Major Projects – Affordable Housing (SSD-72700708) – Lot 1 DP 843470; 25-27 Boyd Street, TWEED HEADS (DA25/0057)

Reference is made to the above proposal and the Department's request for Council's advice/comment on the proposed development. Council at the meeting on 20 March 2025 endorsed the draft submission provided to the Department on 10 March 2025.

Figure 28 Ground floor plan of the proposed development

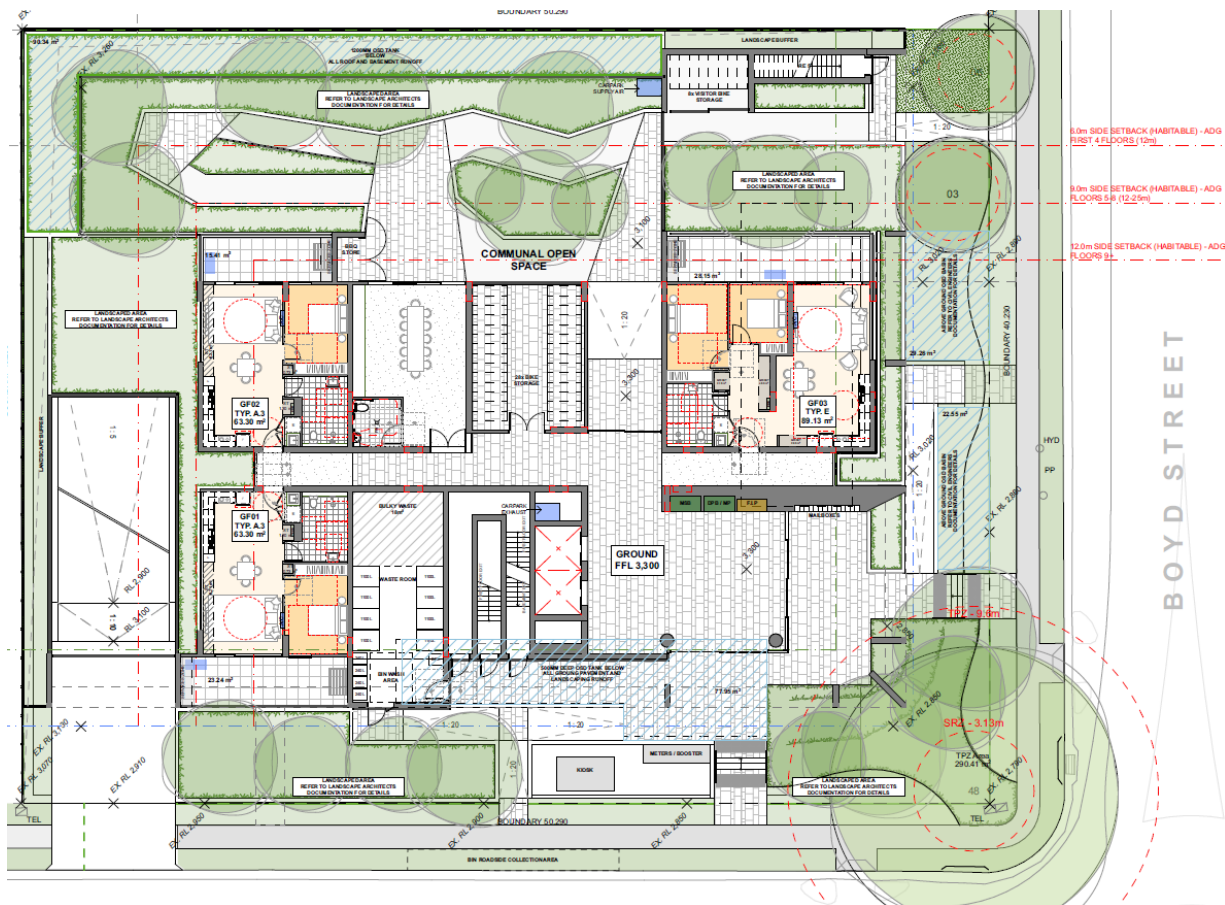
The waste area on ground floor appears to immediately adjoin apartment GF01. This is not consistent with the Tweed City Centre DCP Section B2 (section 6.6 d). The applicant is requested to provide information that demonstrates compliance with the objectives of the DCP.

1 Basement Carpark Lvl 2
SCALE 1:200 @ A3

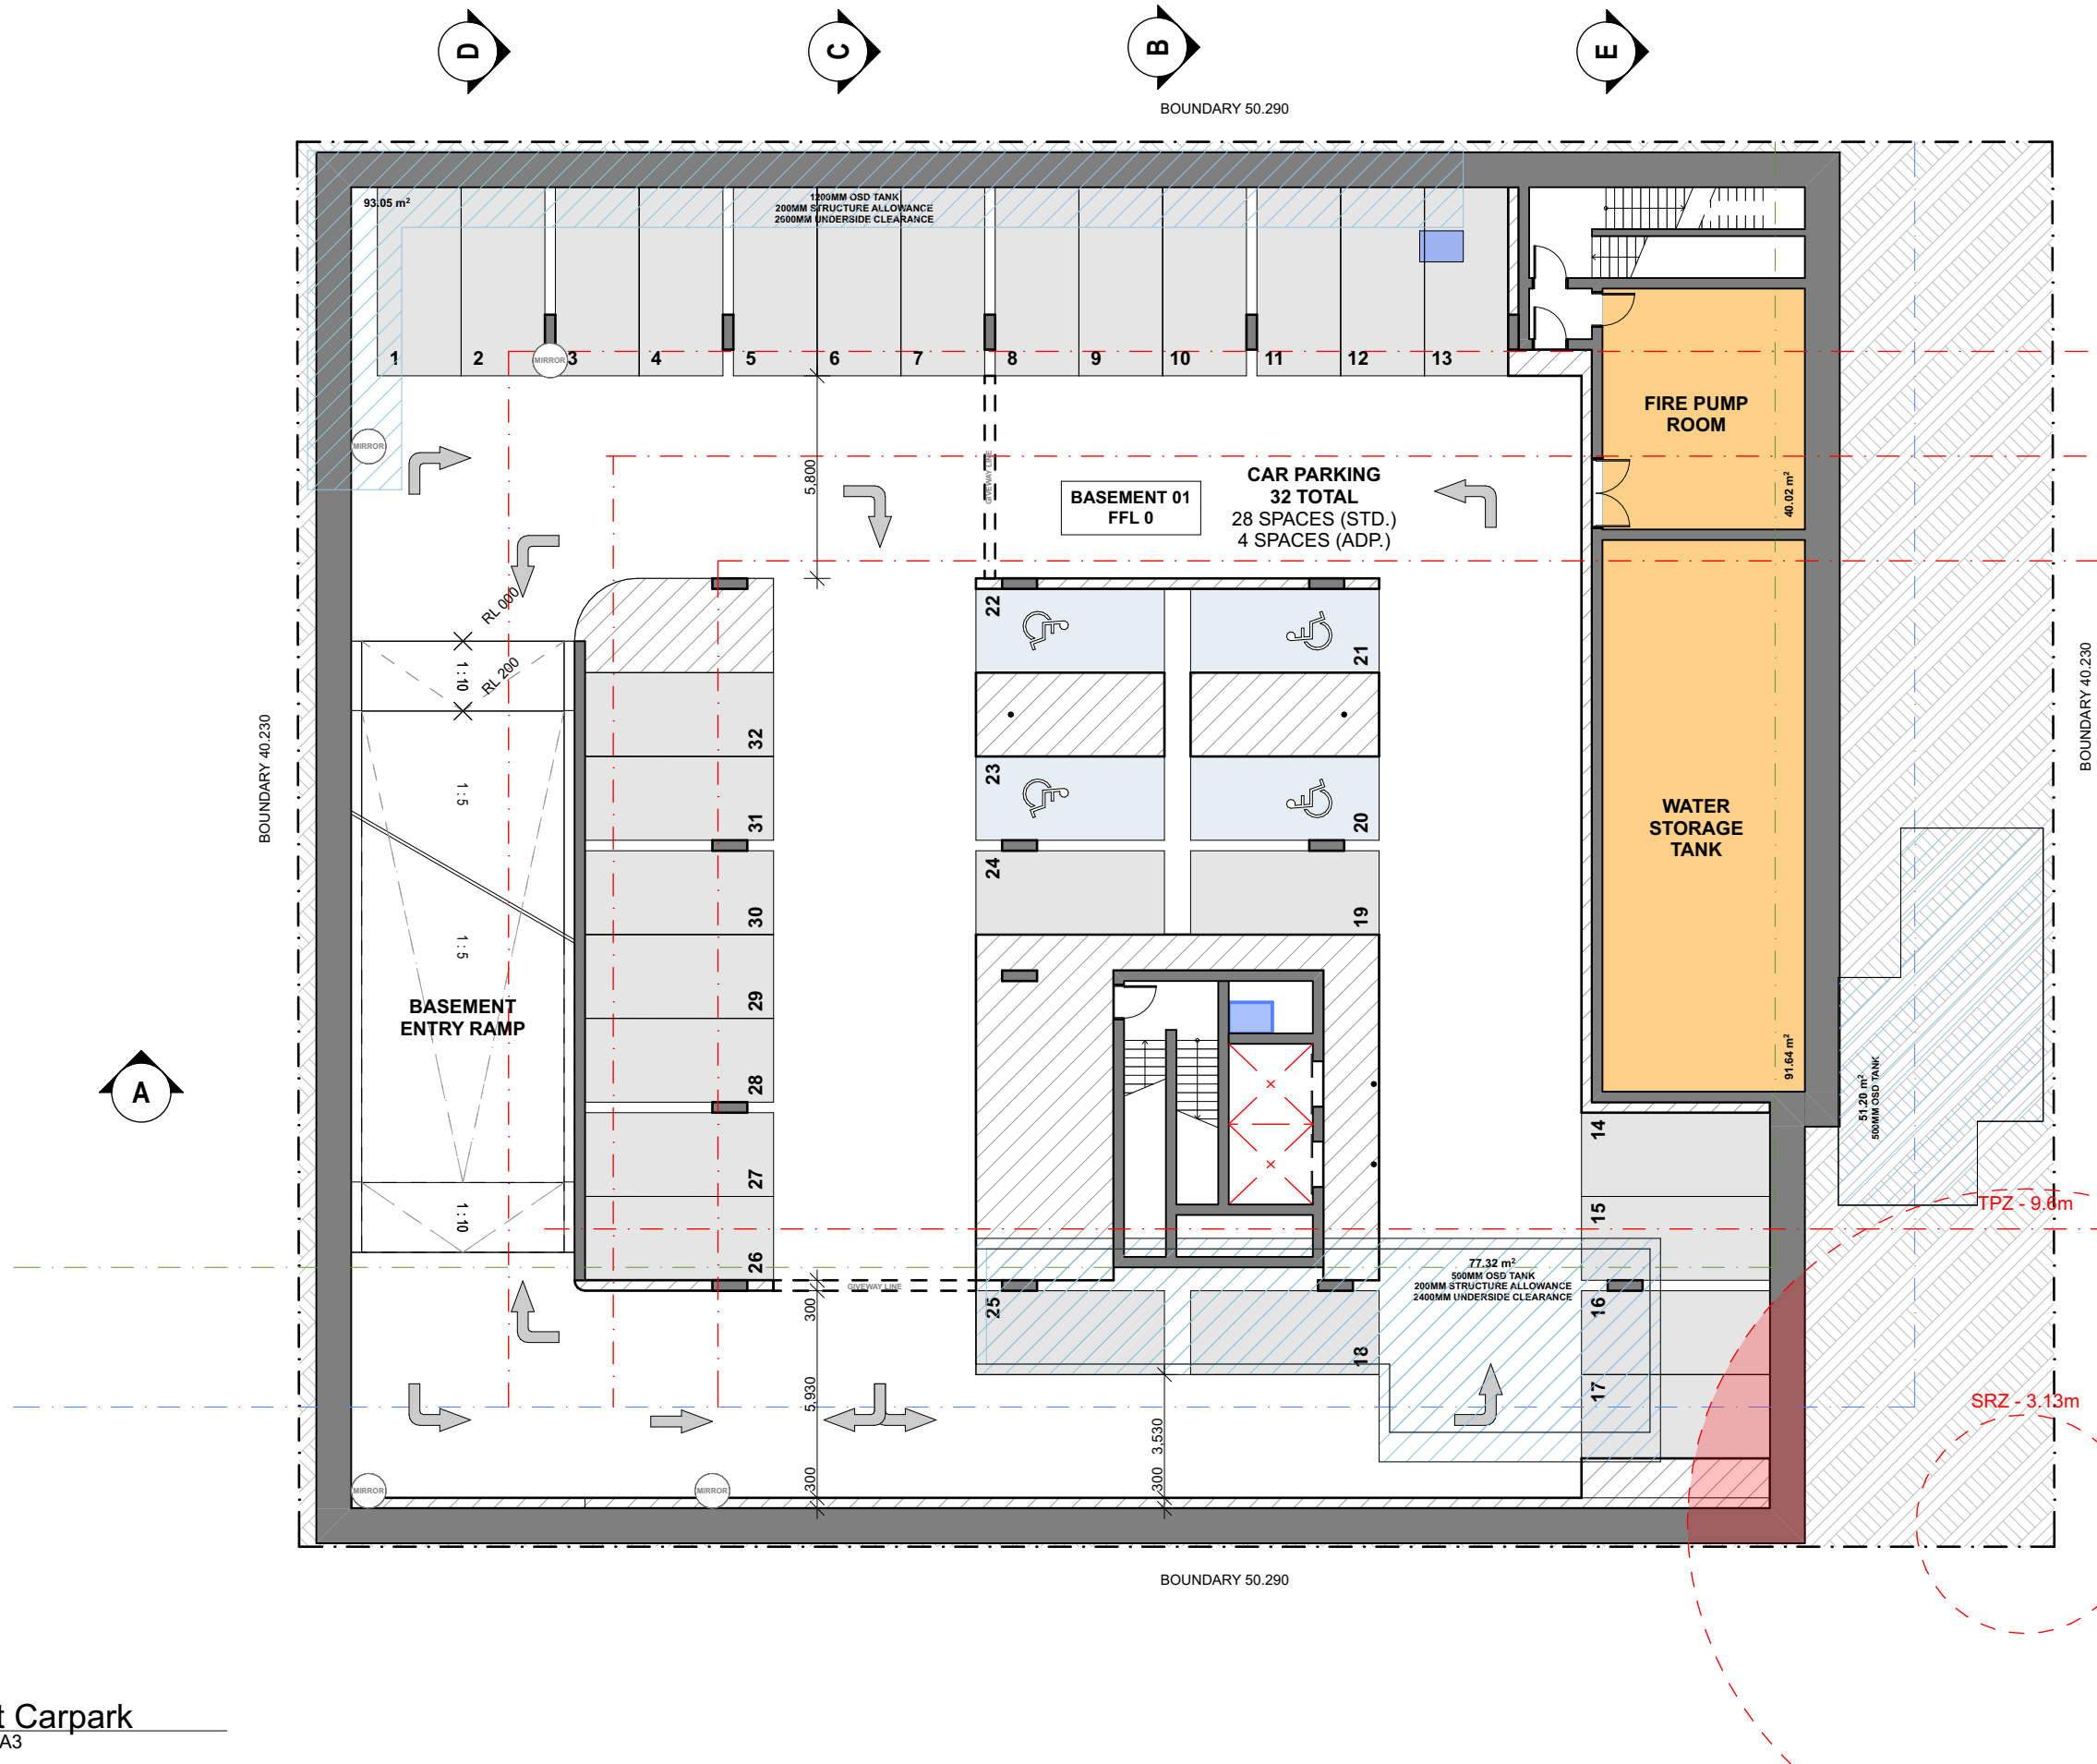
An oil and sediment device with a minimum 0.7m³ sediment sump is proposed to treat runoff from the basement car parking area (level 1). No provision has been made for stormwater quality for the level 2 basement car park.

The Stormwater Management Report is to be updated to address stormwater quality for both levels 1 & 2 of the basement car parking to comply with Council's Development Design Specification D7 – Stormwater Quality (Section D7.12.1 for pollutants generated from undercover or basement areas).
